Department of Transportation

December 29, 2021

RE: Conexus Business Park
DA-27-2021-595 - Phase 3 - Preliminary/Final PD Site Plan

Figure 3

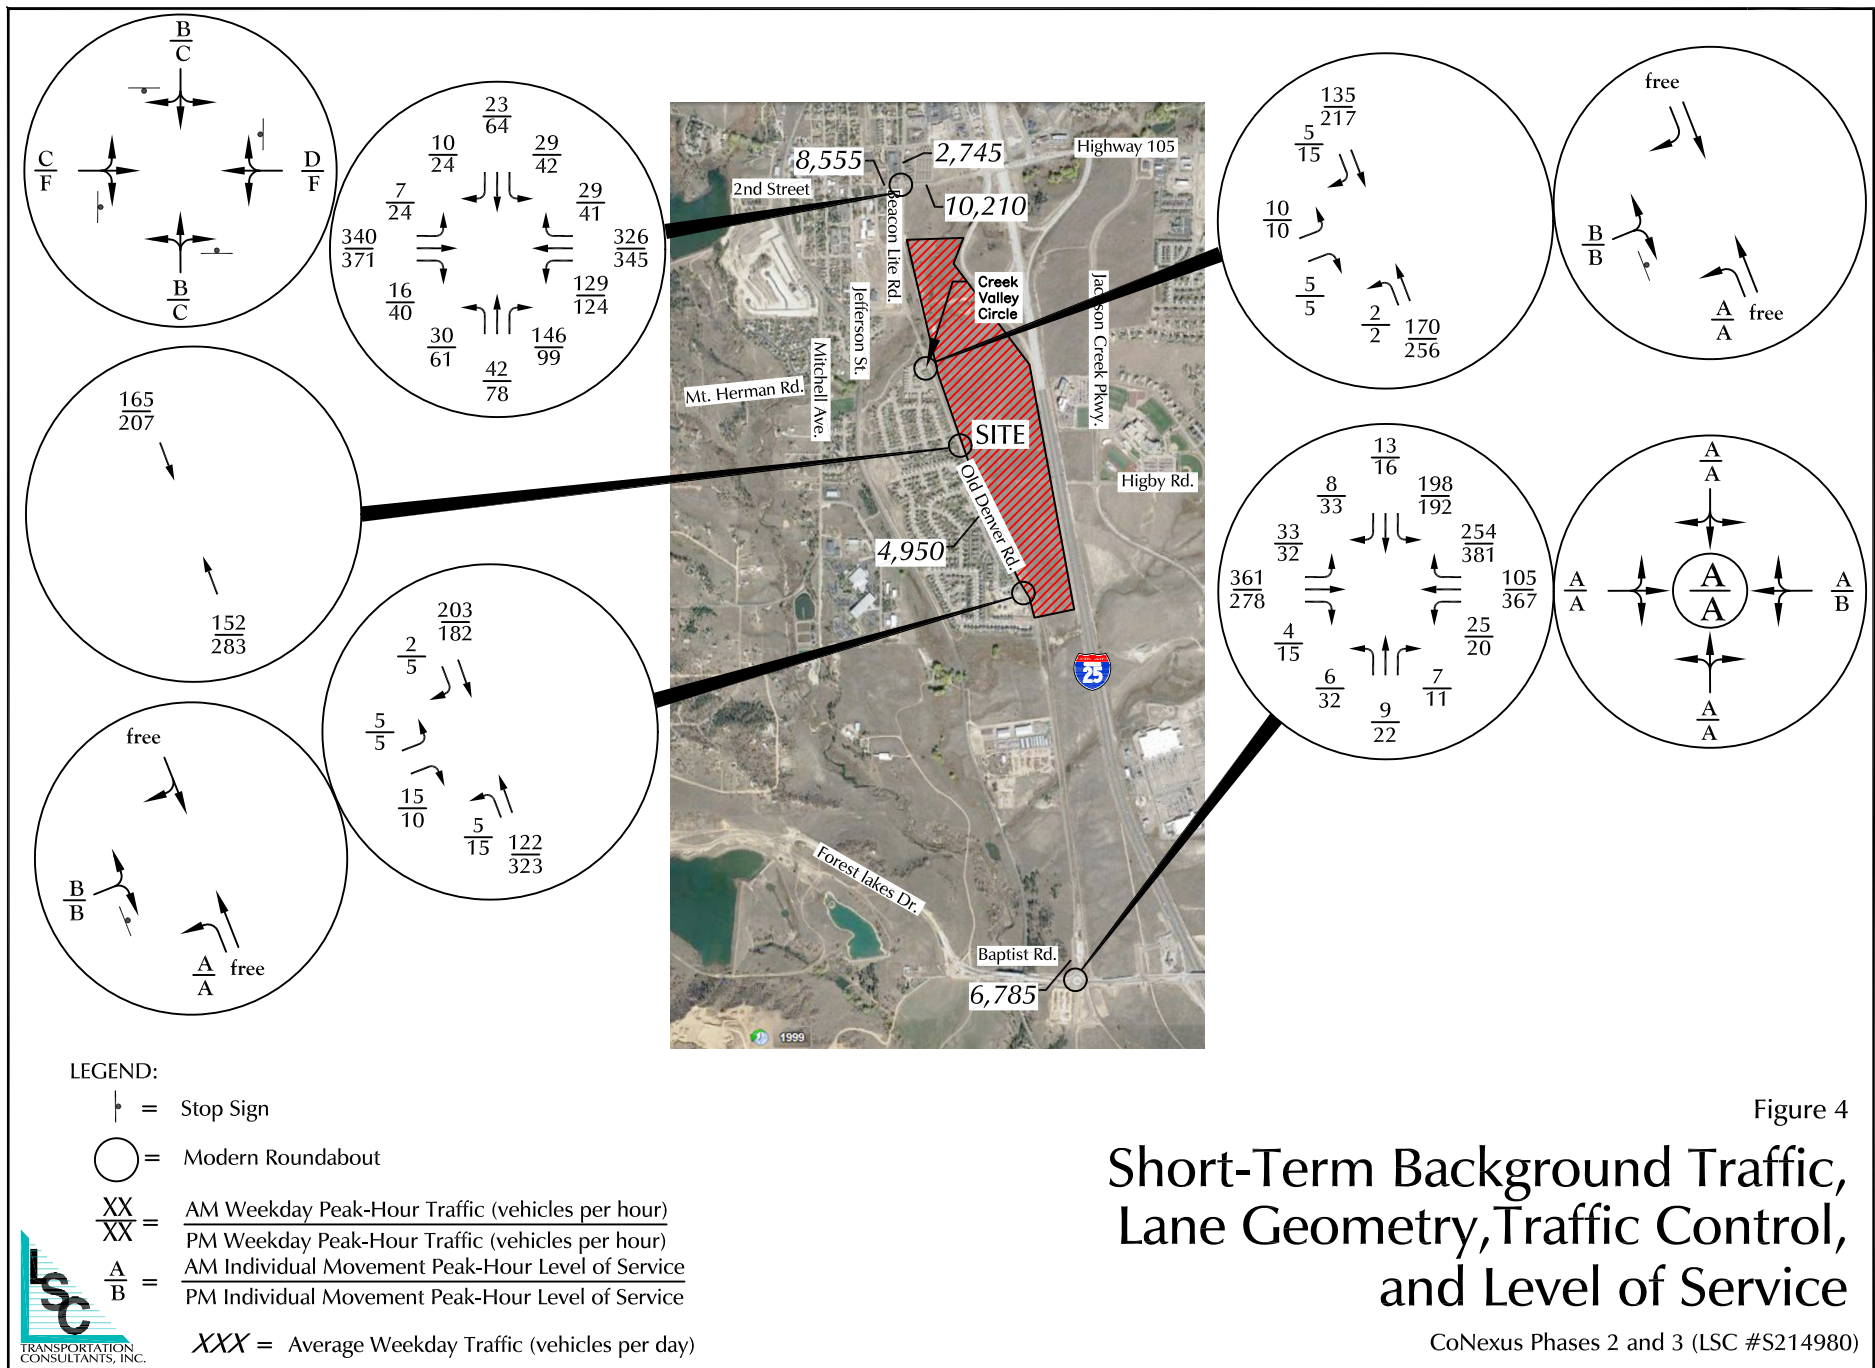
- The study area should be expanded to where newly generated site traffic represents 5 pe more of roadway's peak hour capacity, (SHAC 2.3(5)(b)). This would include the interse Baptist Rd with Terrazzo Drive and the intersection of Second St with Hwy 105 & I-25 SB The intersection of Second St with Hwy 105 & I-25 SB ramps is of particular inter limited queuing capacity along Second St.

LSC Response:
Comment noted. The intersection of Baptist/ Terrazzo has been added to the TIS. The applicant intends to initiate the access permit process shortly, but requests that initially review the TIS and send a review letter and indicated if deemed "acceptable."

LSC Response:
Comment noted. This intersection has been added to the TIS.

CONEXUS PHASE 2 & 3 PROPOSED DRAINAGE MAP

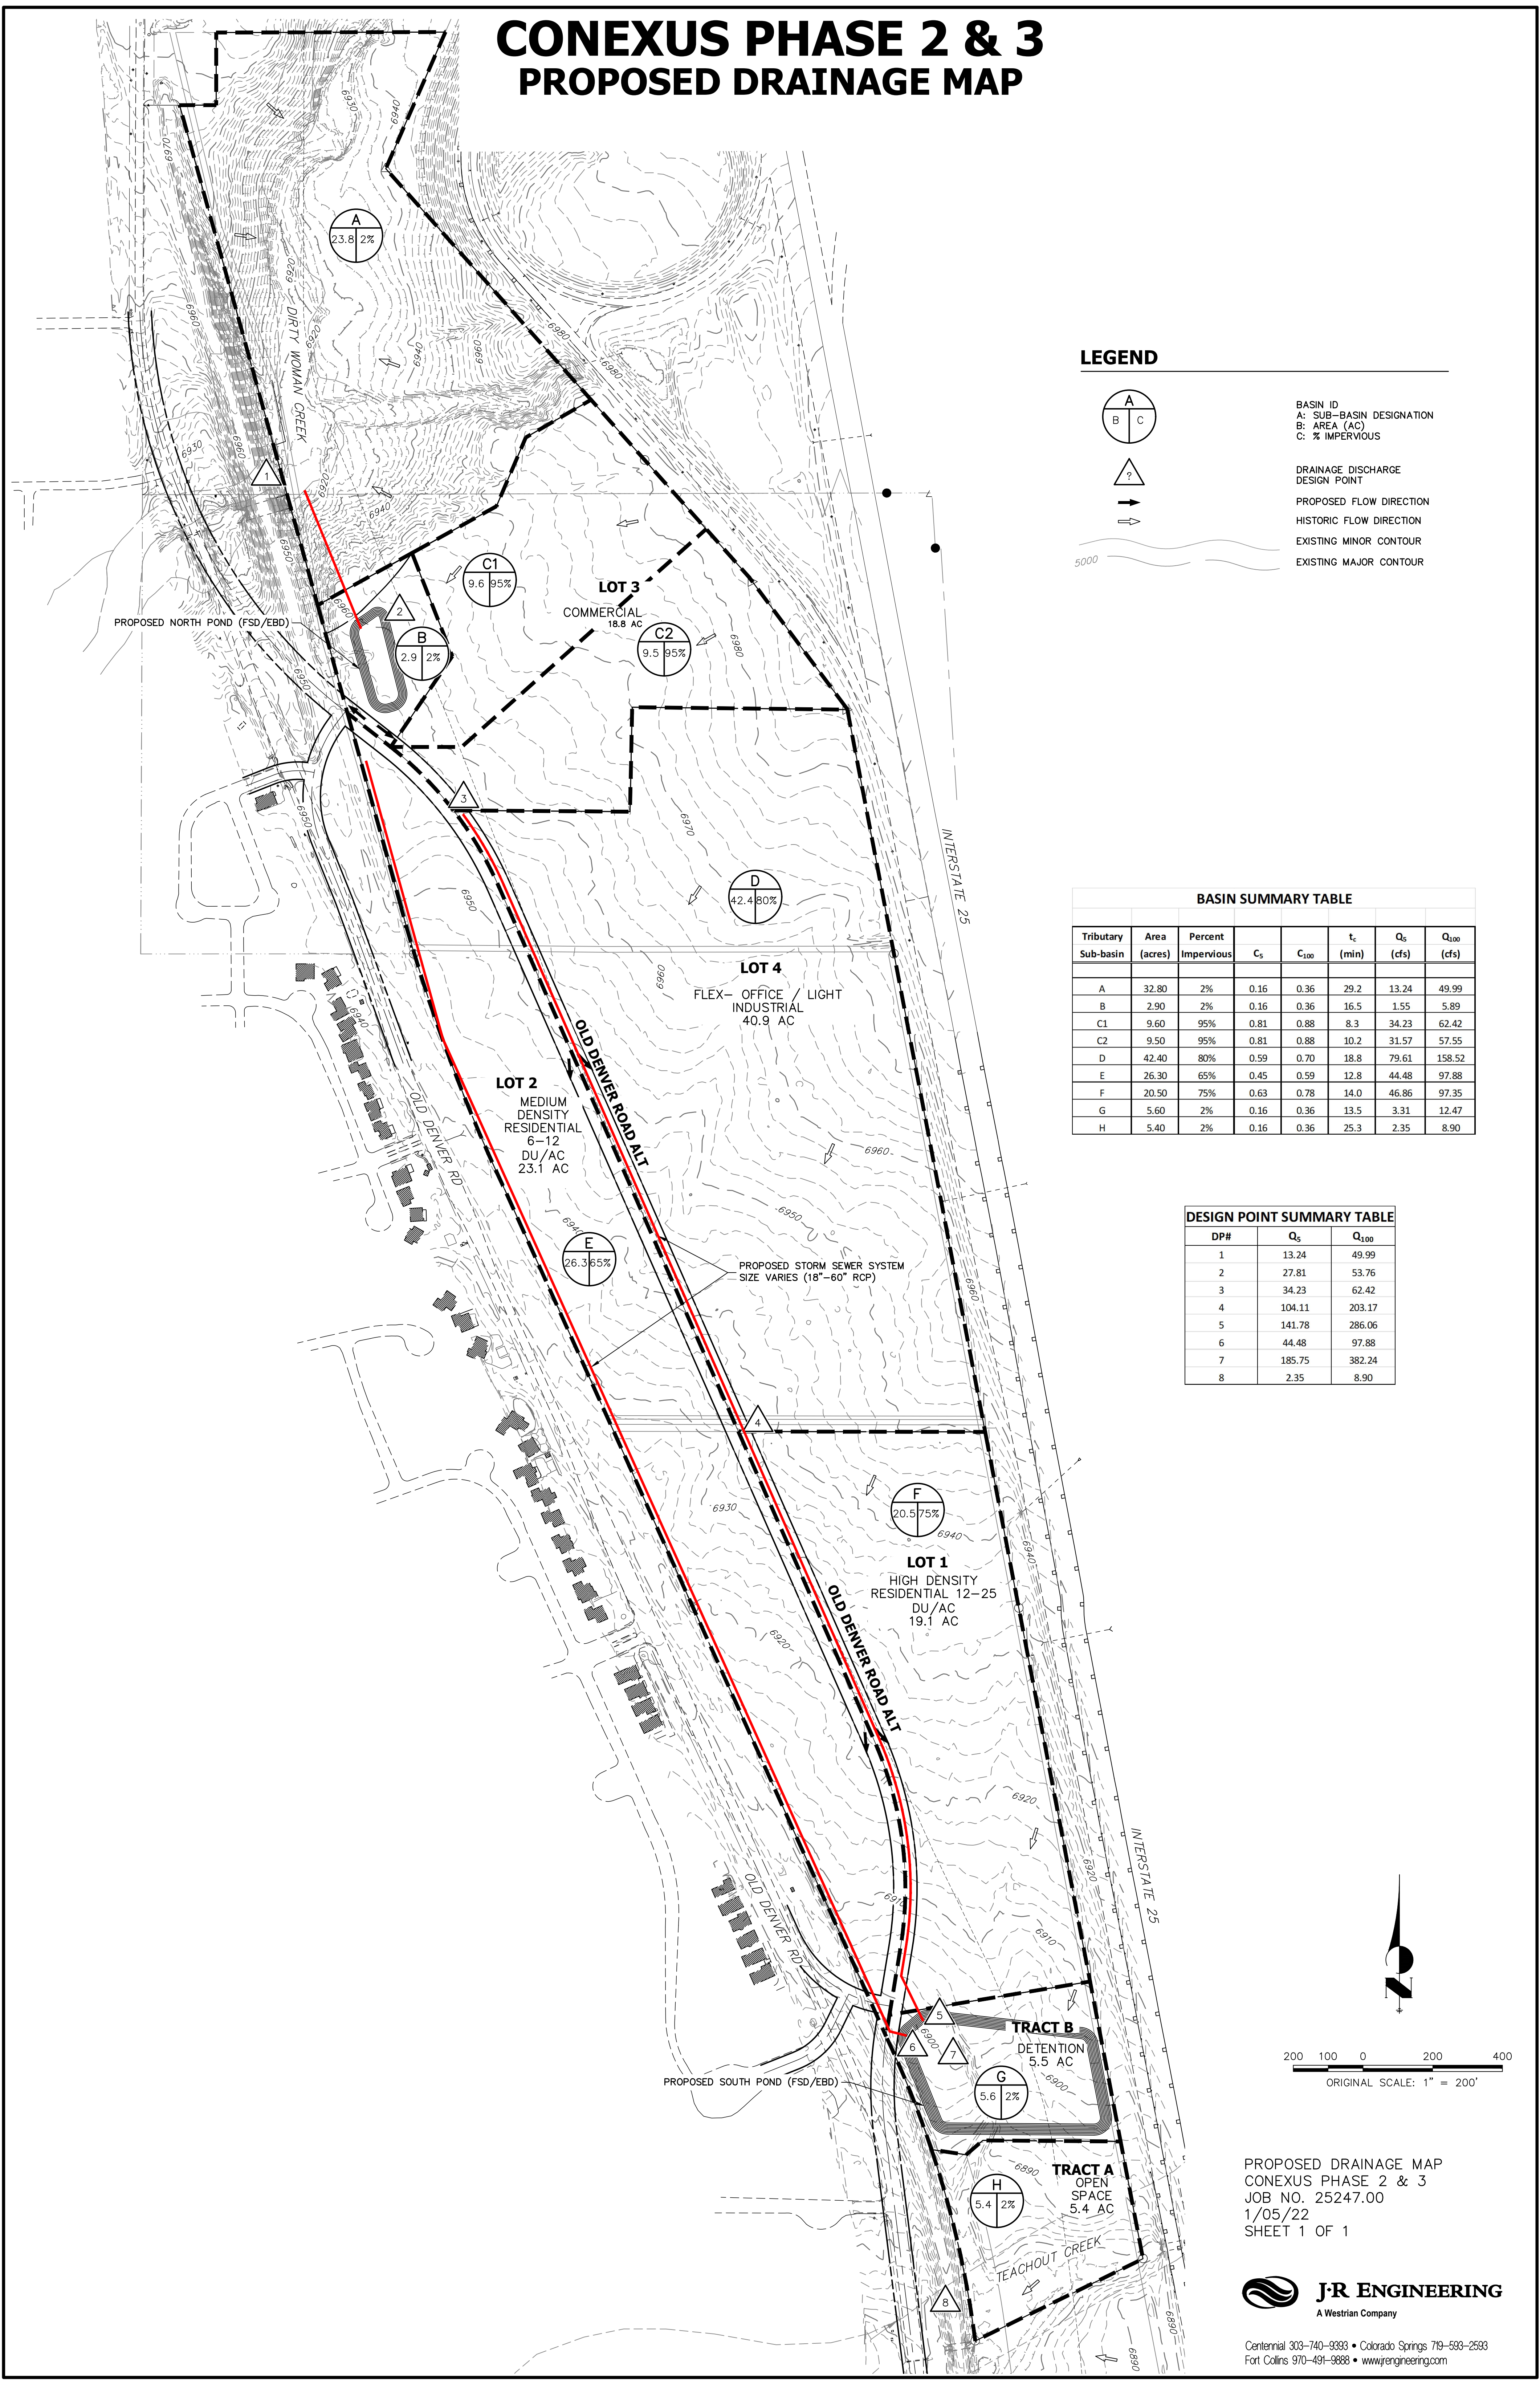
- No drainage concerns for CDOT as drainage is away from I25. Provide to USAFA for review as drainage is onto their property.
- Flow is away from CDOT property therefore no drainage impacts to CDOT. Provide review package to USAFA as flow is onto their property. Provide to I25 corridor manager.

The preliminary drainage letter is acceptable as submitted however USAFA will need to be provided a review package as drainage and flow is onto their property. Provide USAFA review comments to the I25 corridor manager.
